RE: Transmittal of Comments – Macham Short Plat (SP-09-00017)

SUBJECT: Macham Short Plat SP-09-00017

Subject: SP-09-00017; Macham Short Plat; 3-Lot Short Plat
SR 970, MP 9.5 Right Vicinity.

K.C.S.P. NO. 09-XXXX
 PTN. OF THE N 1/2 OF SEC. 28, T.20N., R.17E., W.M.
 KITTITAS COUNTY, WASHINGTON

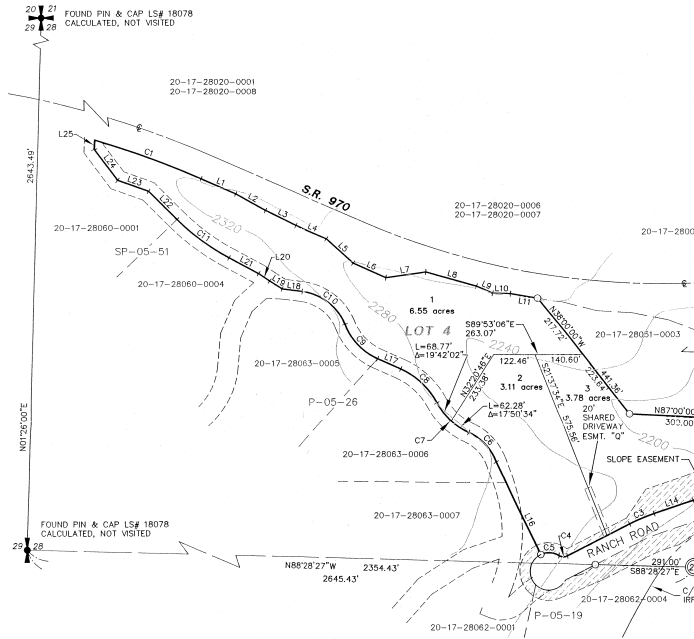
3. Access Lots 2 and 3: The exact location of access to Lots 2 and 3 shall be determined prior to final approval. Access may not be allowed at the location identified on the preliminary short plat. To allow access at the identified location, the applicant shall submit profiles and a drainage report to show there will be no impacts to the slope or drainage associated with construction of the driveway. The profiles and drainage report shall be prepared by an engineer licensed in the state of Washington. The County Engineer will make the final decision after review of these documents.

4. Private Road Improvements: If Lots 2 and 3 are required to be accessed from Mountain Creek Drive, the following road and cul-de-sac improvements shall be required. Mountain Creek Drive, from Ranch Road to the entrance to Lot 4, shall be constructed to meet or exceed the conditions of a High-Density Private Road that serves 15-40 tax parcels. A cul-de-sac or hammerhead turnaround shall be constructed at the entrance to Lot 4. See current Kittitas County Road Standards, 9/6/05 edition.

- a. Access easements shall be a minimum of 60' wide. The roadway shall have a minimum width of 22', with 1' shoulders, for a total width of 24'.
 - b. Minimum centerline radius shall be 60'.

5. Cul-de-Sac: A hammerhead or cul-de-sac turn-around having an outside right-of-way or easement diameter of at least 110 feet shall be constructed at the closed end of all dead-end roads serving 3 or more lots. The driving surface shall be at least 96 feet in diameter. Cul-de-sacs and hammerheads must also conform to the requirements specified by the 2006 International Fire Code. Contact the Fire Marshal regarding any additional cul-de-sac requirements.

6. Joint-Use Driveway: If access to Lots 2 and 3 is allowed from Ranch Road, the driveway shall be constructed to the following standards. A joint-use access shall serve no more than two tax parcels. See Kittitas County Road Standards, 9/6/05 edition.

1. The subject property is adjacent to State Highway 970. SR 970 is a Class 1 access managed highway in this area with a posted speed limit of 60 miles per hour. No direct access for any of the proposed lots will be allowed to SR 970 per WAC 468-52-040 (1). We request the following:

- Show access for Lot 1 to County road (Ranch Road).
 - A note be placed on the plat that states that no direct access to SR 970 will be allowed from this plat.
